Application No: FG/46/21/PL
Site Address: Land between 11a The Grove and 30 Brook Lane Ferring
Description of works: Development of 1 no. 2 bed house set over 2 floors, with first floor being partially contained within roof, along with associated parking & amenity spaces. This site is within CIL Zone 4 and is CIL liable as new dwelling.

Thank you for your internet representation made on 29th April 2021 which has been recorded as an objection with the comments as follows:

Drawing Title 028_07 Proposed West & South Elevations Land between 11A The Grove and 30 Brook Lane, Ferring	
Completion date 17/03/2021	
Drawn by Guy Rochez	
Scale: 1:100@A3	
Print Size: A3	
Notes:

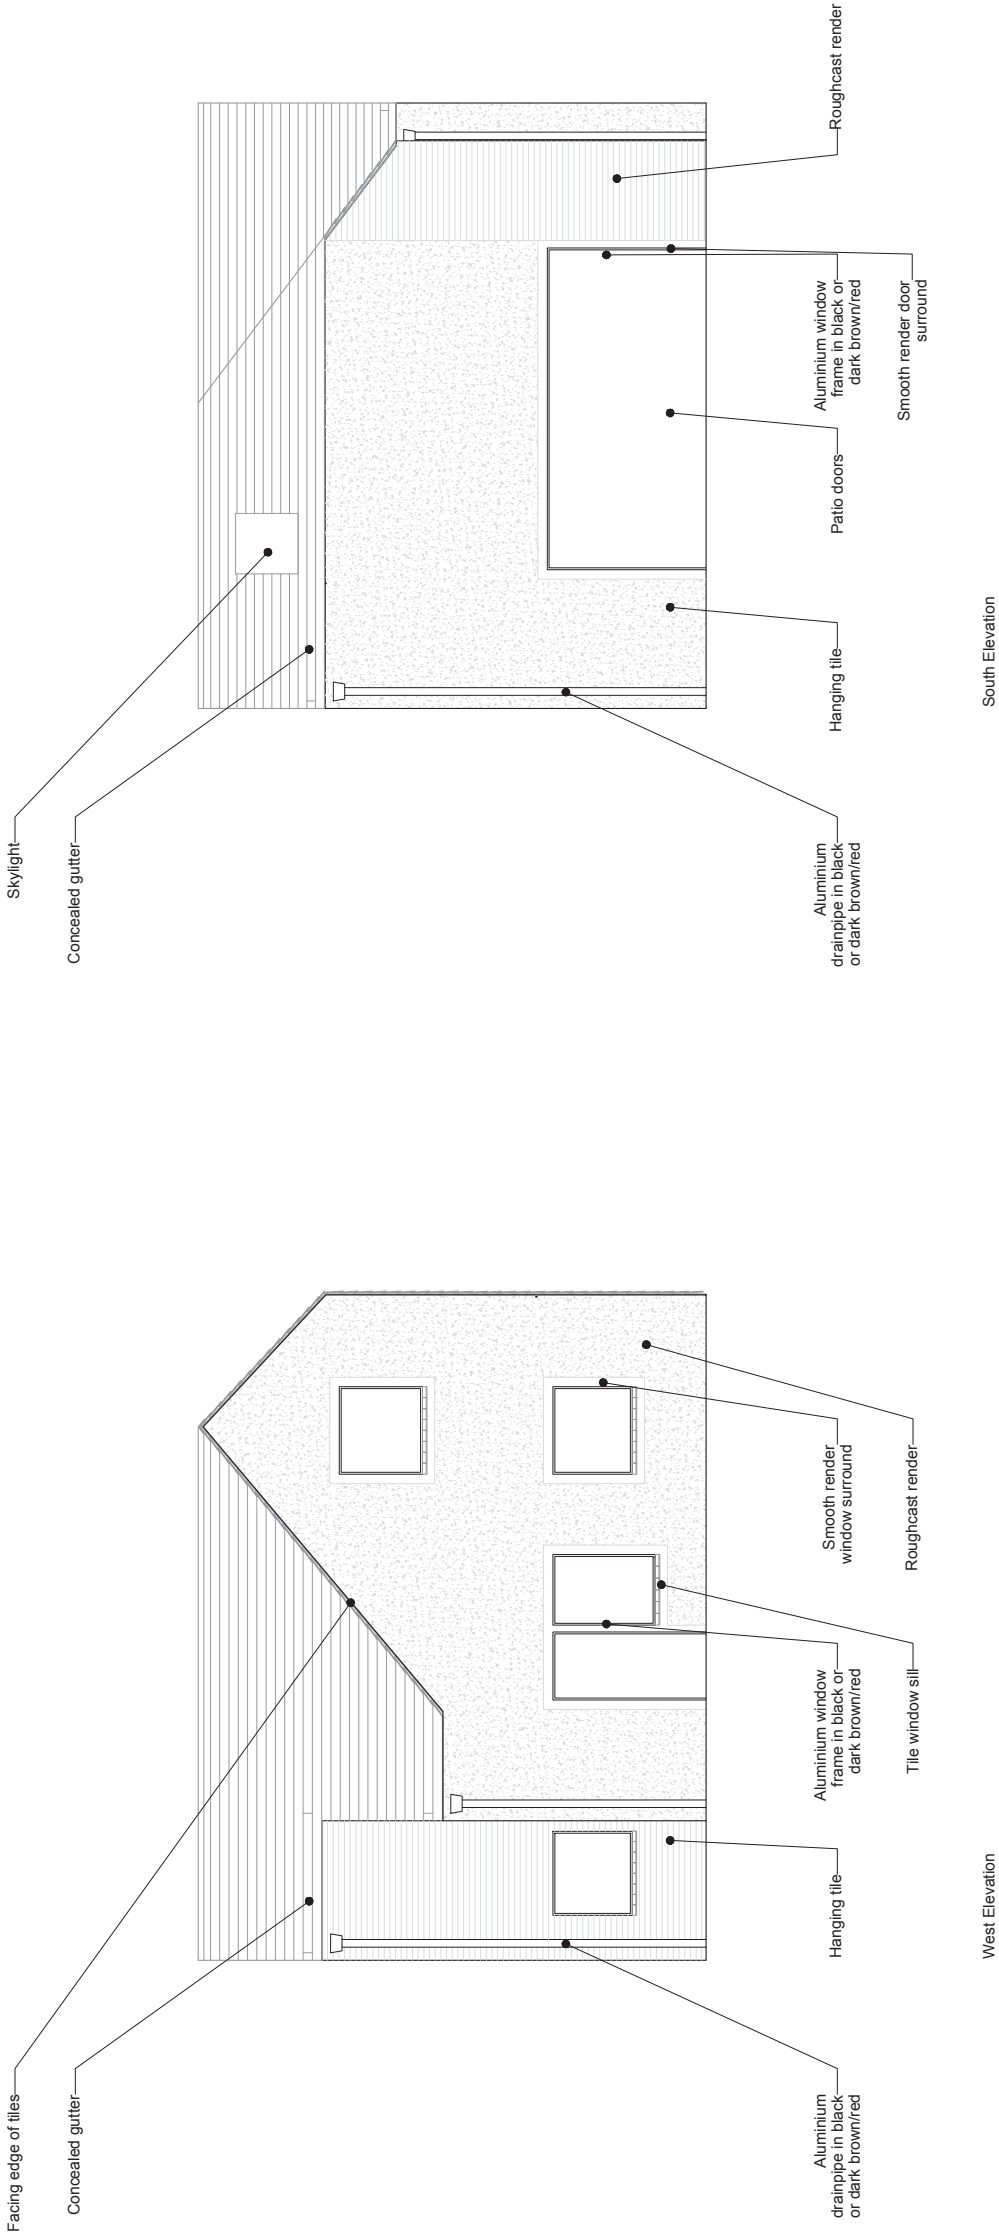
This is an over development of the site. The North elevation is only 6/7 meters from our lounge windows, and will reduce the daylight in our lounge and put our front garden into the shade. Our privacy will be compromised by the position of the property's living room windows.

Drawing Title 028_02 Proposed Ground Floor Plan Land between 11A The Grove and 30 Brook Lane, Ferring					
Completion date 17/03/2021					
Drawn by Guy Rochez ARB					
Scale: 1:100@A3					
Print Size: A3					
Notes:

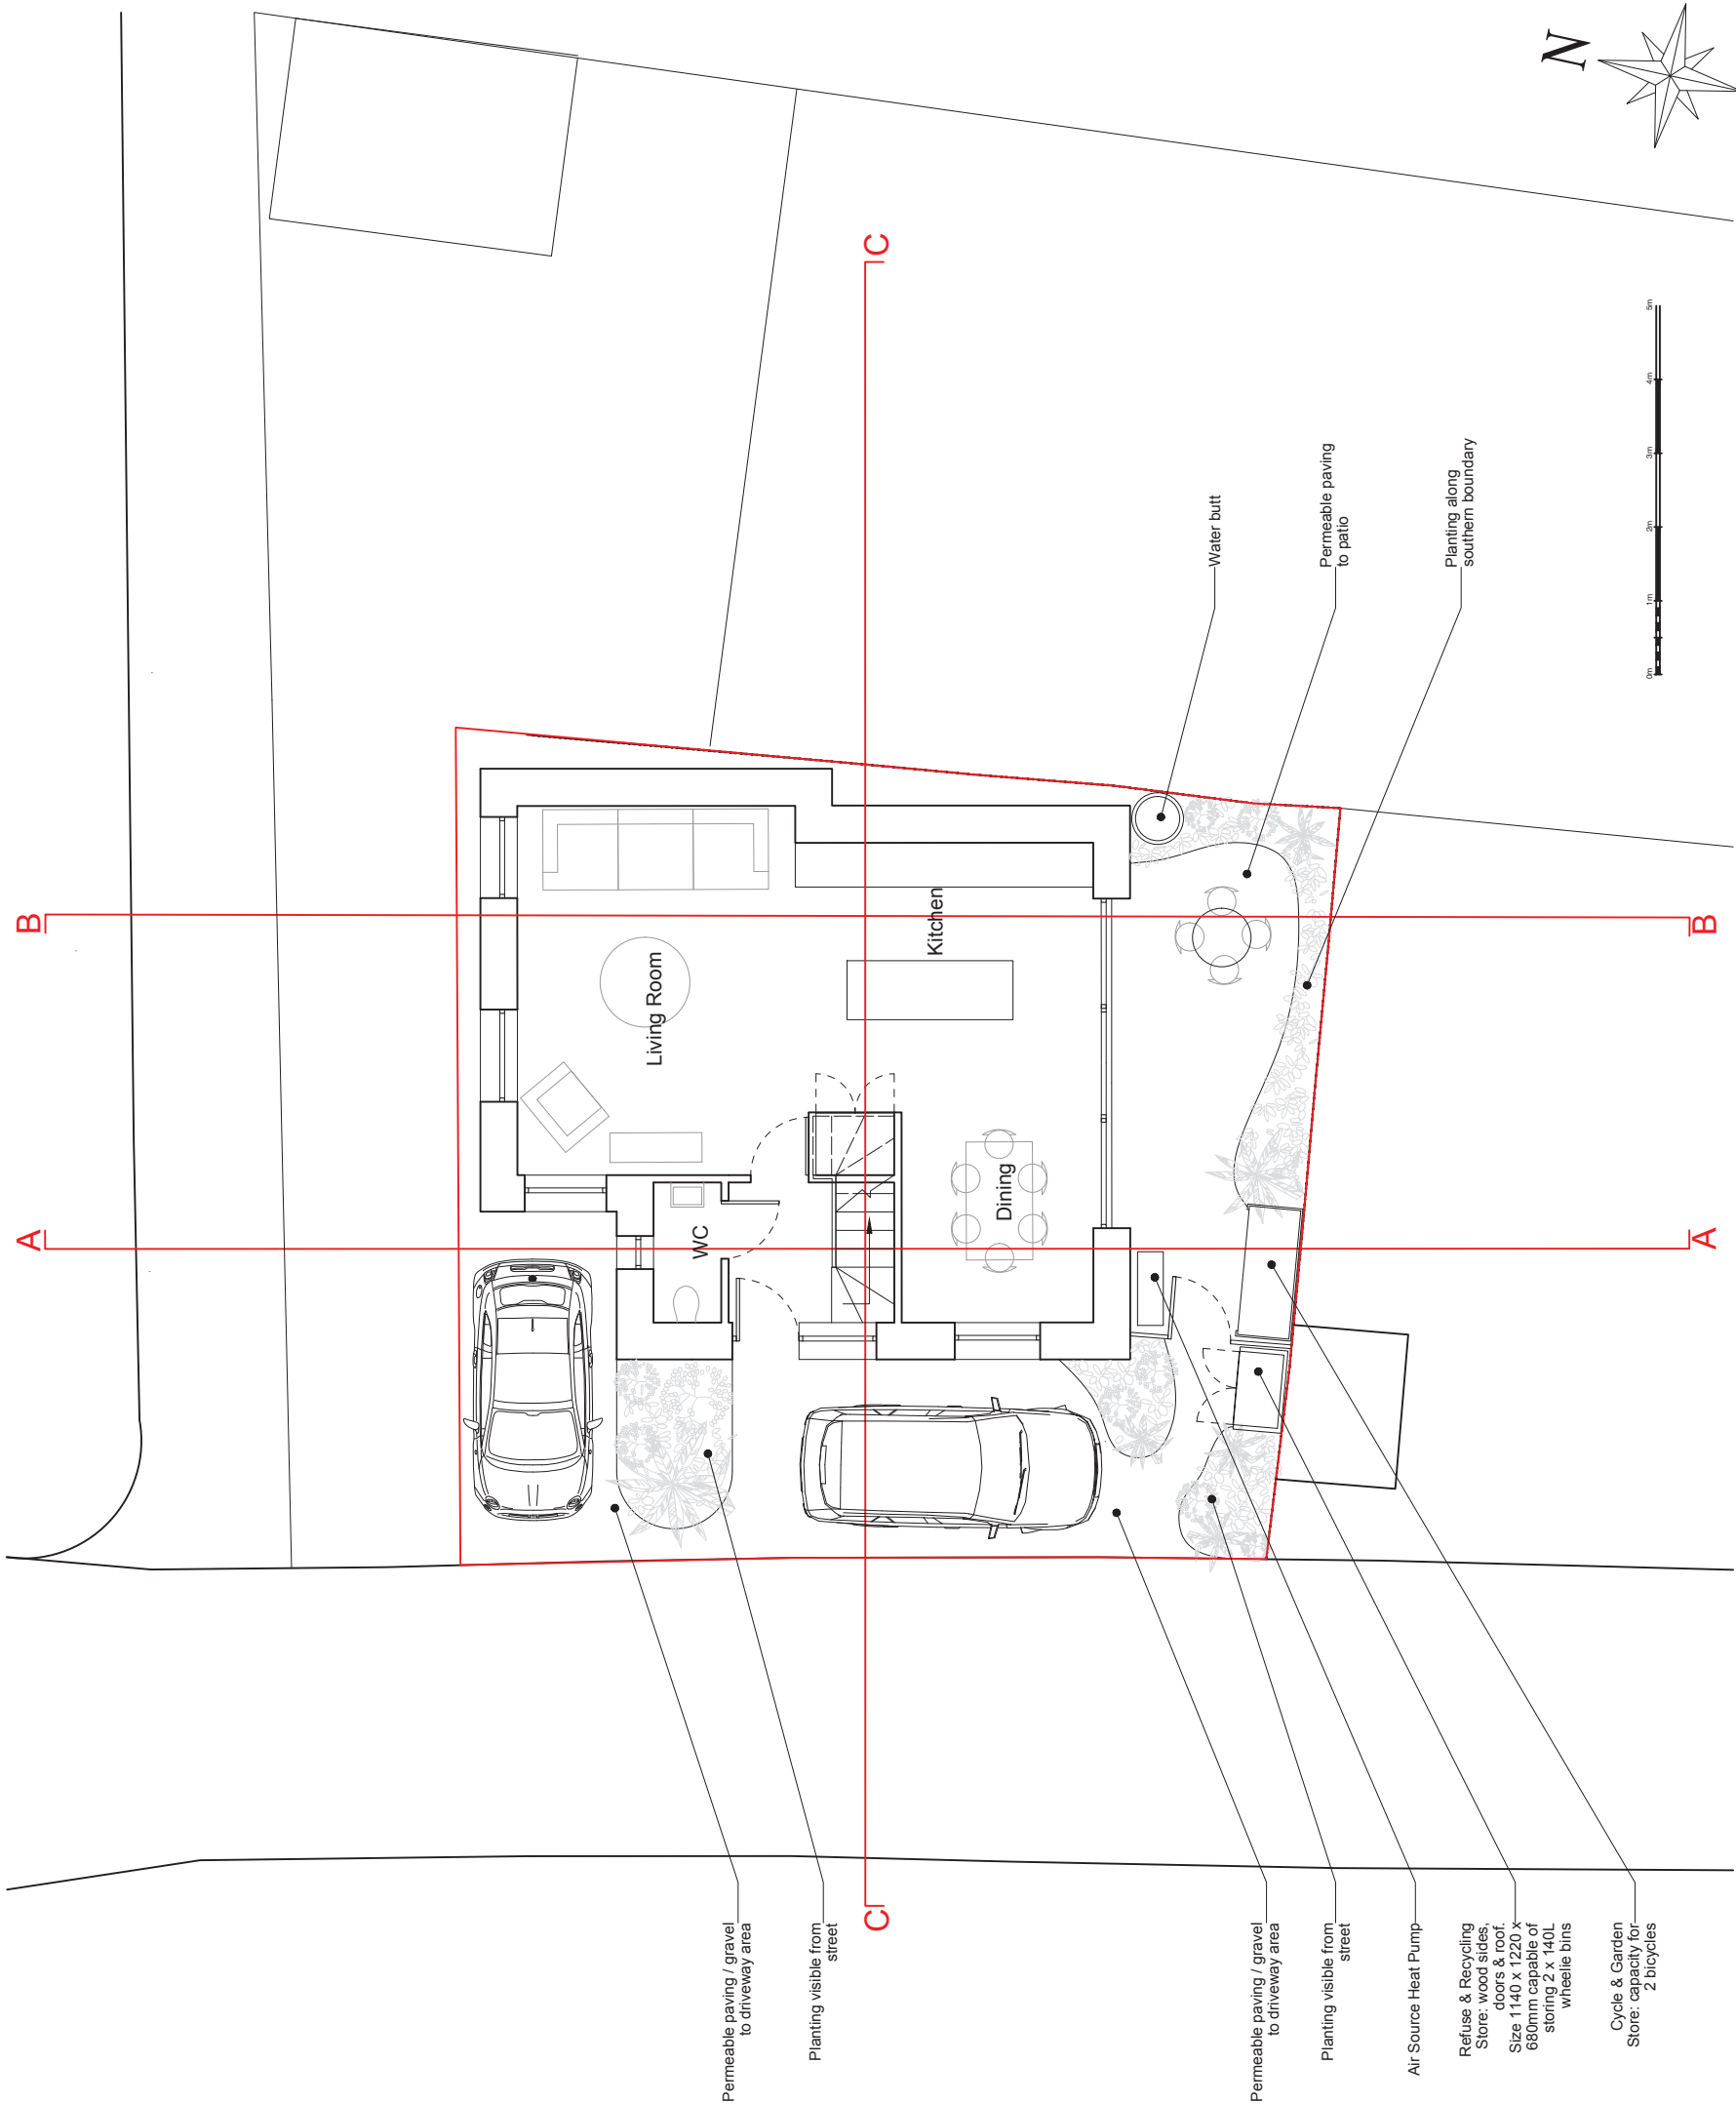
The parking space nearest to us is too small and a car will overhang the road and our neighbours driveway. I am worried that my view of the road will be obscured by an overhanging car blocking my view of the road.
